Our Ref: BR/67/22/DOC

Approval of details reserved by condition imposed under BR/281/18/PL relating to conditions 3-site meeting with ADC tree officer & Arboricultural Expert, 7-landscape details & 9-details of new screen walls and/or fences.

99 Victoria Drive Bognor Regis PO21 2DZ

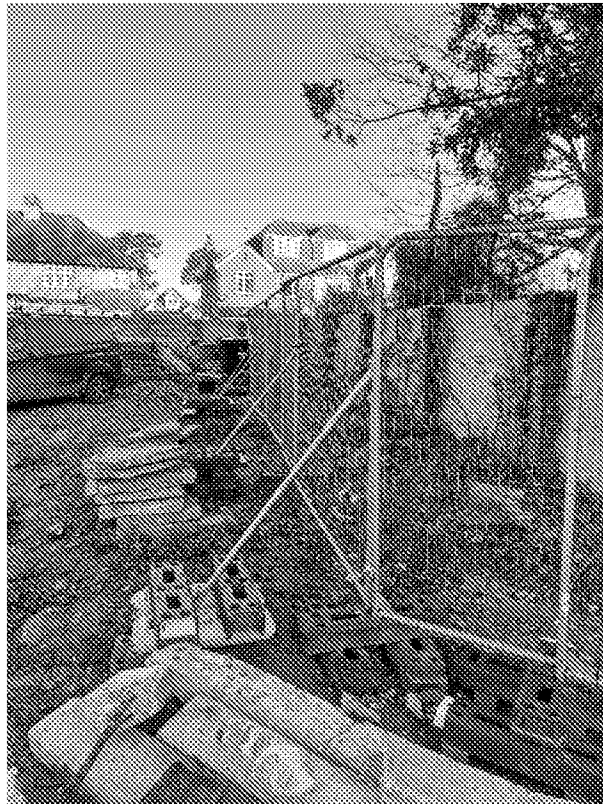
ADC's Tree Officer visited the site on 27th January 2022. Protective fencing had been erected on site although not to the required standard. Although the position of fencing appeared correct, the installation was not and did not form an effective construction exclusion zone.

The current application for discharge of condition 3 provided photographs demonstrating improved tree

protection fencing.

Condition 3 can be discharged insofar as it relates to the details submitted. The condition has other elements which may need to be discharged if the situation arises e.g. the provision re utility service routes.
